# OXFORDSHIRE COUNTY COUNCIL'S RESPONSE TO CONSULTATION ON THE FOLLOWING DEVELOPMENT PROPOSAL

**Application no:** 23/00853/OUT

**Proposal:** Outline application for up to 170 dwellings (Use Class C3) with associated open space and vehicular access off Warwick Road, Banbury; All matters reserved except for access

**Location:** Land East Of Warwick Road Drayton, Warwick Road, Banbury

Figure 5.2: Proposed Highway Layout

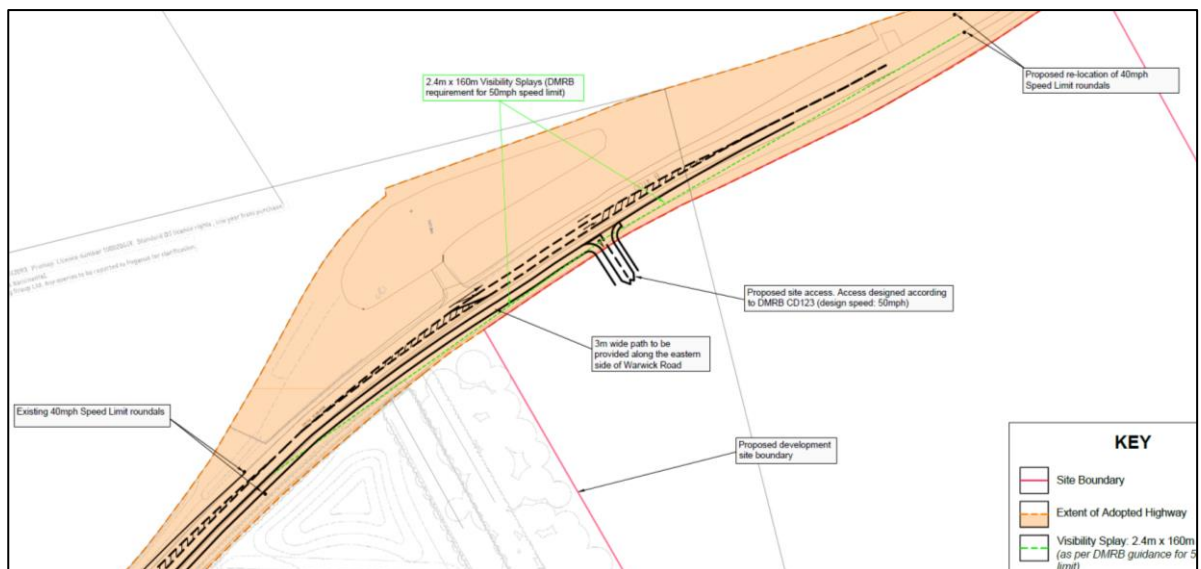
The main access to the site will be obtained from the B4100 Warwick Road via a priority T-junction which will comprise of a dedicated right turn lane. I note the access layout states that the ghosting and access are to be designed to DMRB, however we would need some detail regarding dimension and measurements to confirm this. **(To be conditioned)**

There has not been a swept path analysis to demonstrate that the largest vehicles anticipated to require access to the site can safely and easily enter and exit from all directions at the site access. Therefore, a condition requesting full details of the site

Appendix C: Proposed Site Access

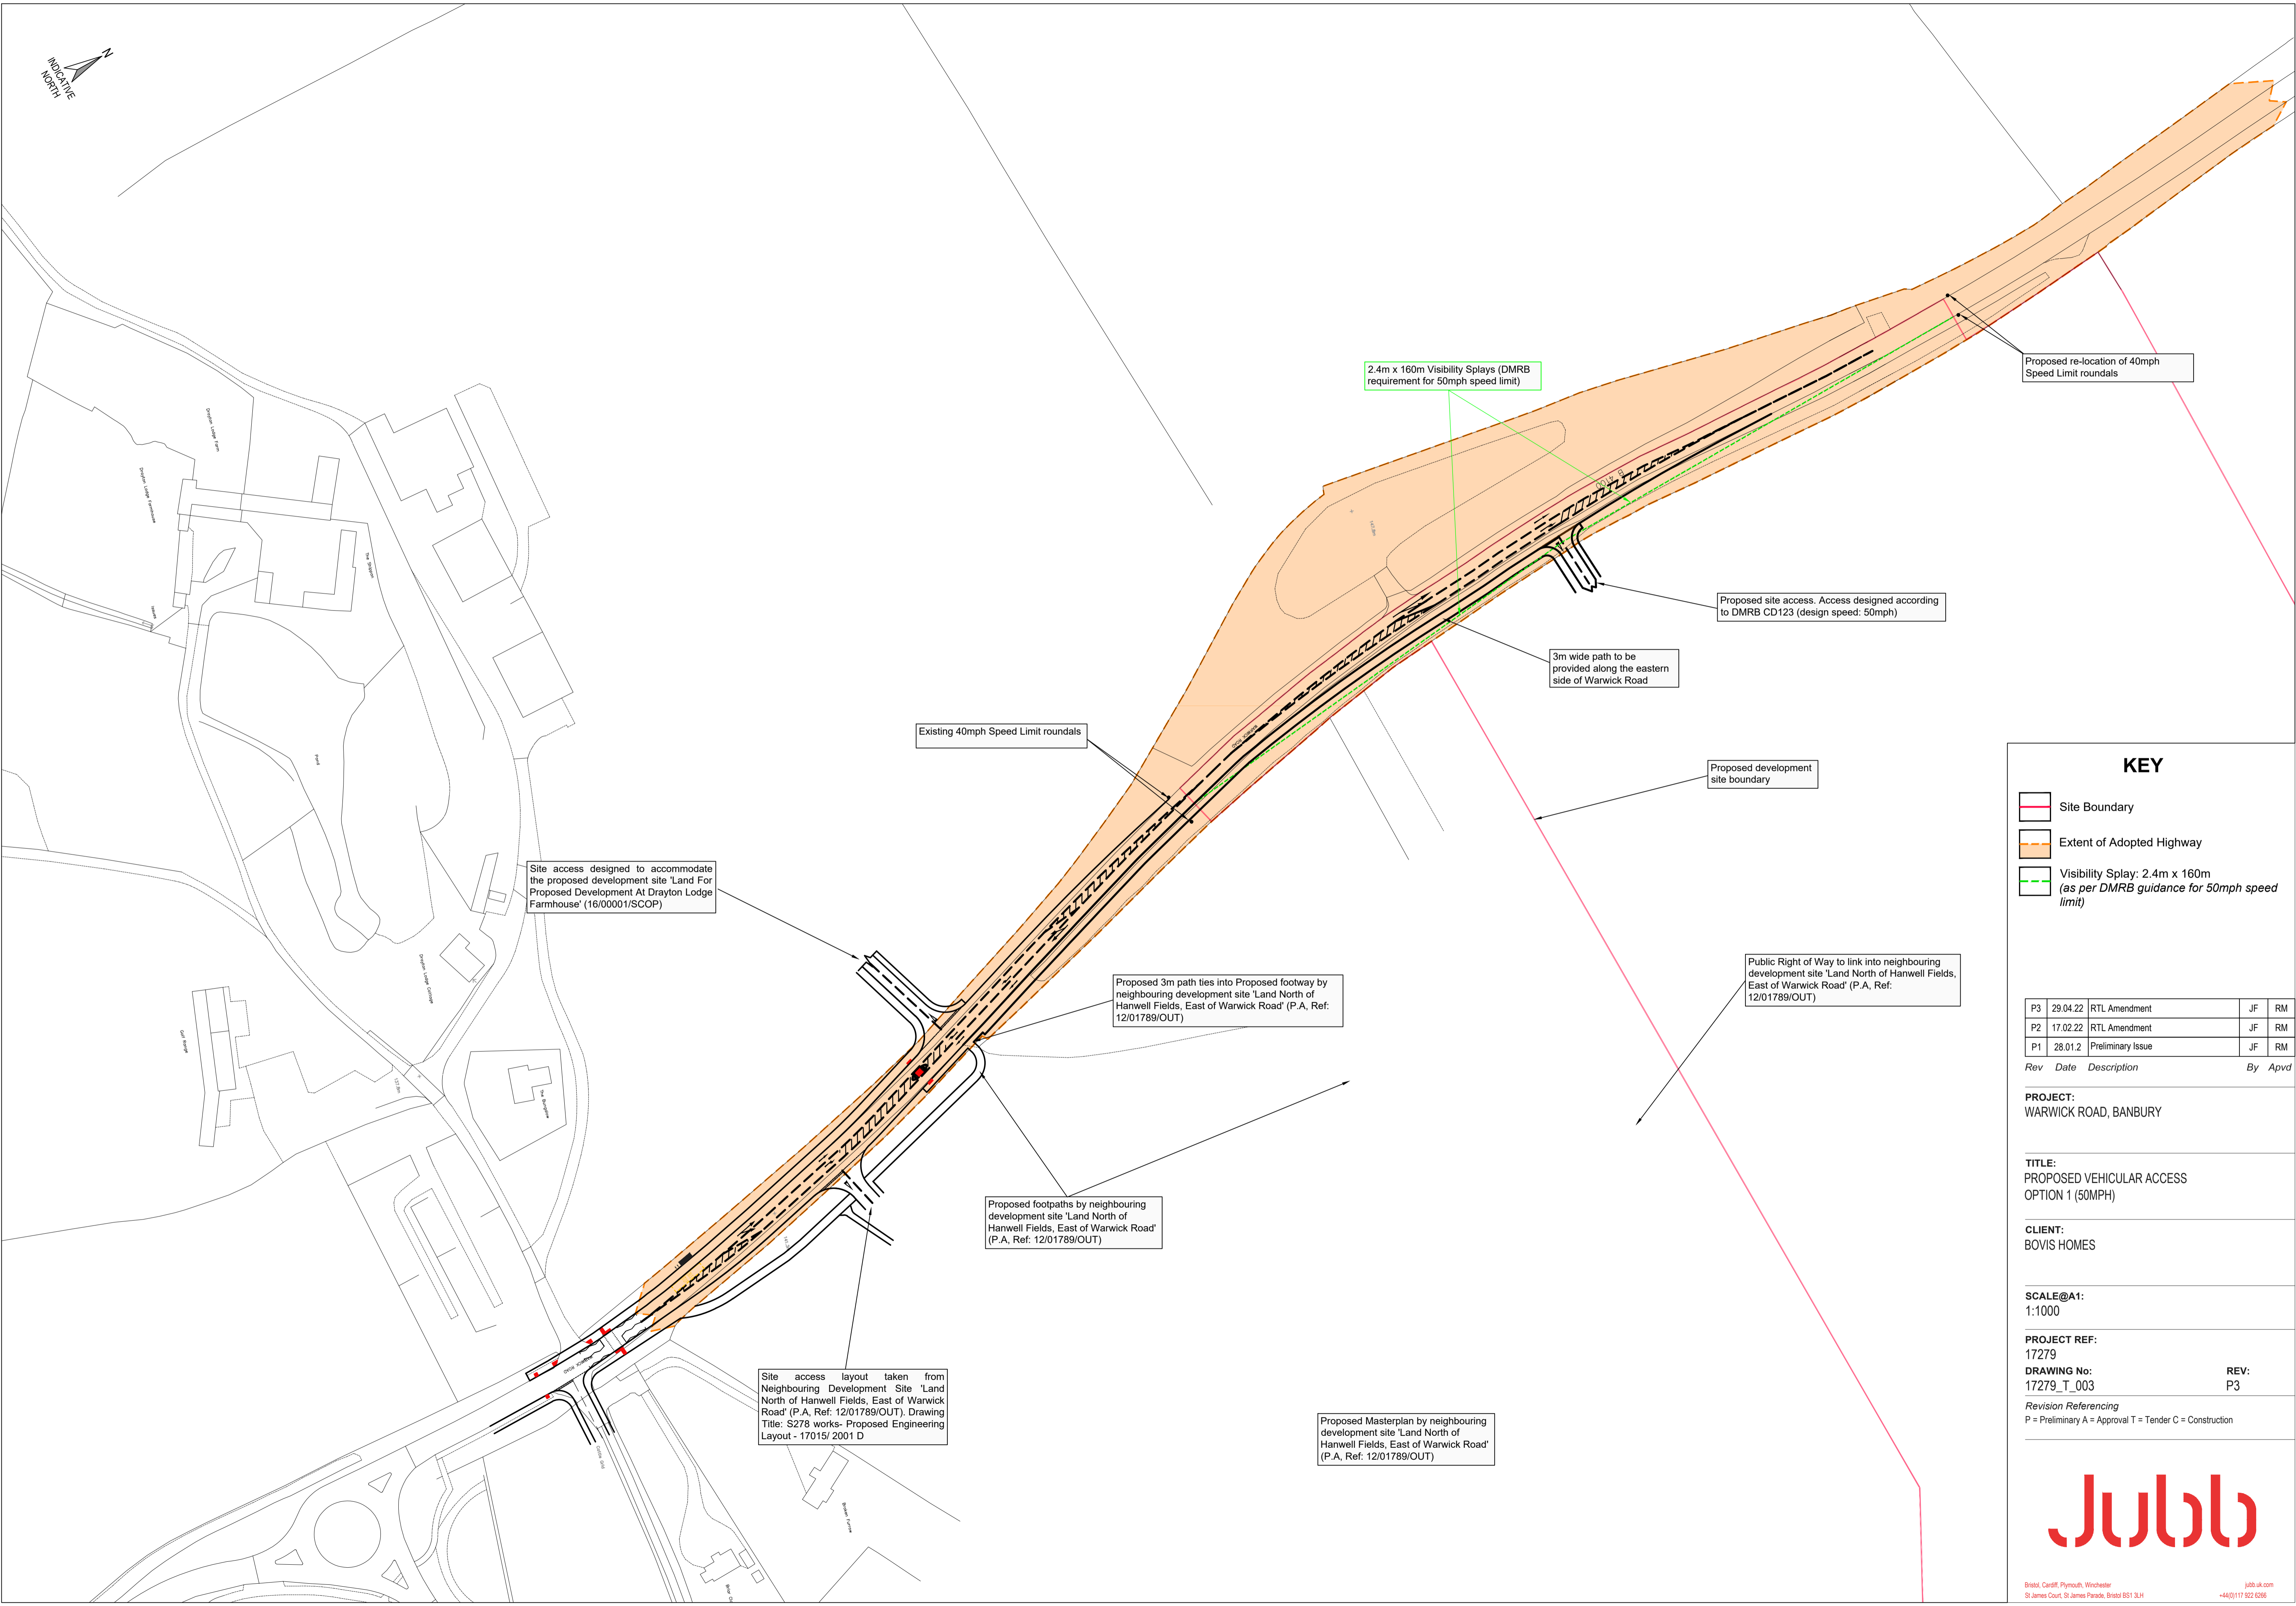
The 'Proposed Vehicular Access Option 1 (50mph)' plan (Drawing No: 17279\_T\_003 Rev P3) included in Appendix E of the TA shows that visibility splays in accordance with standards set out in the DMRB for the 85th percentile speeds on the adjacent highway can be achieved at the site access. Based on the speed survey results, the county council is satisfied that the visibility splays at the site access accords with the relevant standards.

access, including a swept path analysis for a 11.6m refuse vehicle, is requested. **(To be conditioned)**

Prior to the commencement of the development hereby approved, details of the means of access between the land and the B4100 Warwick Road including position, dimensions and layout shall be submitted to and approved in writing by the Local Planning Authority. Thereafter, and prior to the occupation of any dwellings, the means of access onto the highway shall be constructed and retained in accordance with the approved details.
